DECISION DELEGATED TO HEAD OF PLANNING

Application No:	H09-1345-21	Applicant:	Gleeson Homes
Proposal:	Details of surface water drainage scheme, construction management plan & method statement, details of precautions to prevent mud deposits on public highways, lighting for roads & footpaths, landscaping, details of management & maintenance for areas of incidental open space, refuse & recycling collection points & parking courts/private drives, management plan for areas of publicly accessible open space & outdoor play areas and schedule of materials (Conditions 5, 6, 7, 9, 12, 15, 16 & 17 of H09-0602-20)		
Location:	Land Off Northon'S Lane Holbeach Spalding		
Terminal Date:	2nd September 2022

CASE OFFICER ASSESSMENT**Proposal**

SITE & MATERIALS LAYOUT

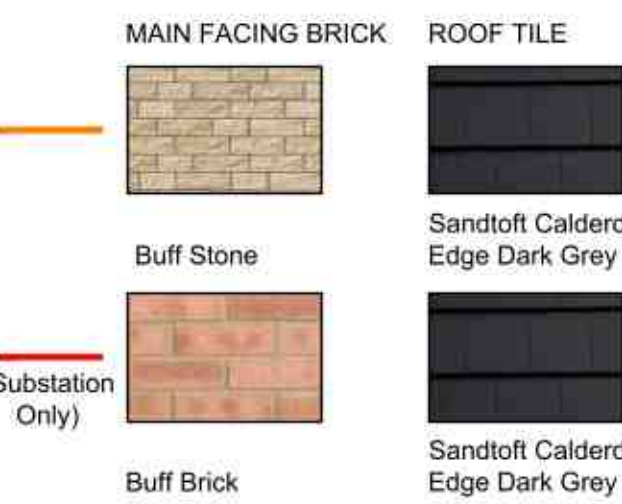
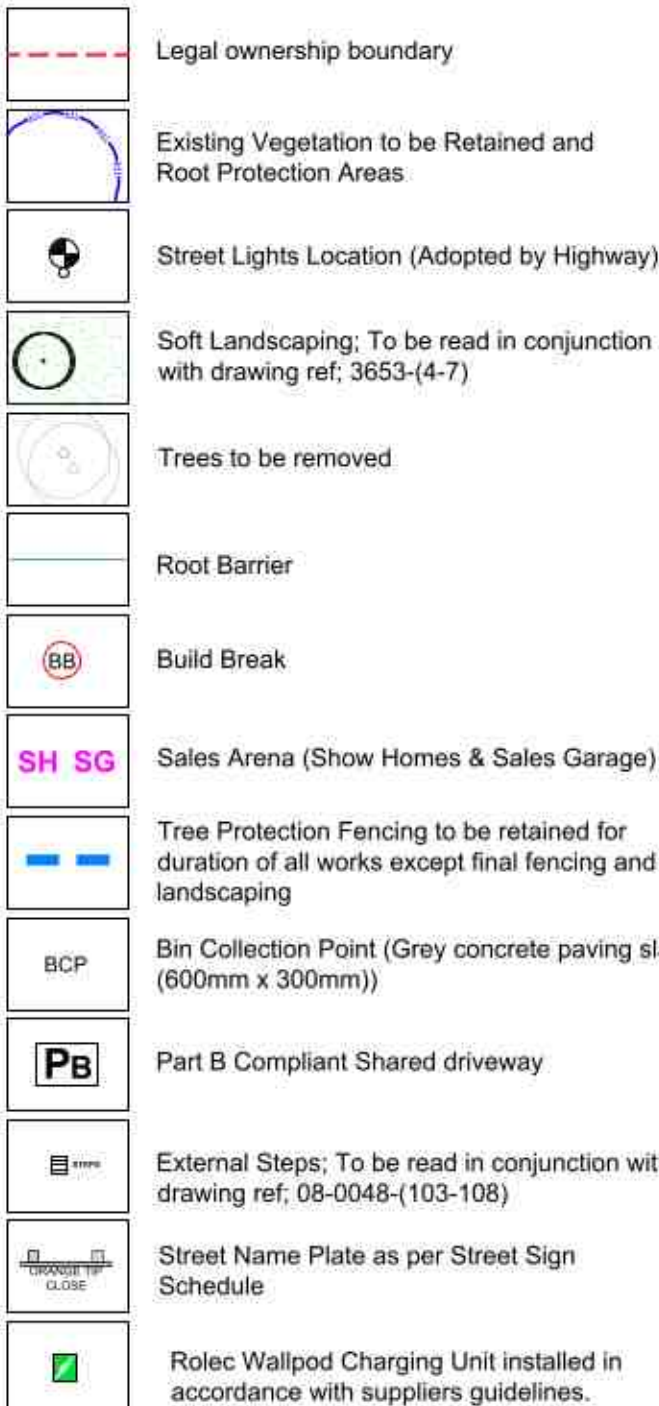
The footpath/cyclepath on the north-eastern boundary, outlined with the red pen on the attached scan of the submitted 3117-A01-01 RevA drawing, is for 'recreational' use. It will not be adopted and can therefore be surfaced with self-binding gravel or crushed aggregate.

The footpath/cyclepath linking the internal estate road network to Boston Road on the east side of the site, outlined with the blue pen, is a vital link to encourage residents of the development to undertake some of their journeys on foot or by cycle. It will therefore be adopted as a public highway, and it must therefore be constructed to LCC adoptable footway specification. i.e. have a bitumen surface.

It is noted that the 3117-A01-01 RevA drawing does include a note (highlighted) identifying that the adoptable footpath/cyclepath (outlined in blue) is to be constructed with a crushed aggregate surface. This would not be acceptable and this note is inconsistent with the Section 38 Agreement drawing.

LCC will not be entering into a Section 38 Agreement for the adoption of the footpath/cyclepath that is outlined in blue if it is surfaced with crushed aggregate.
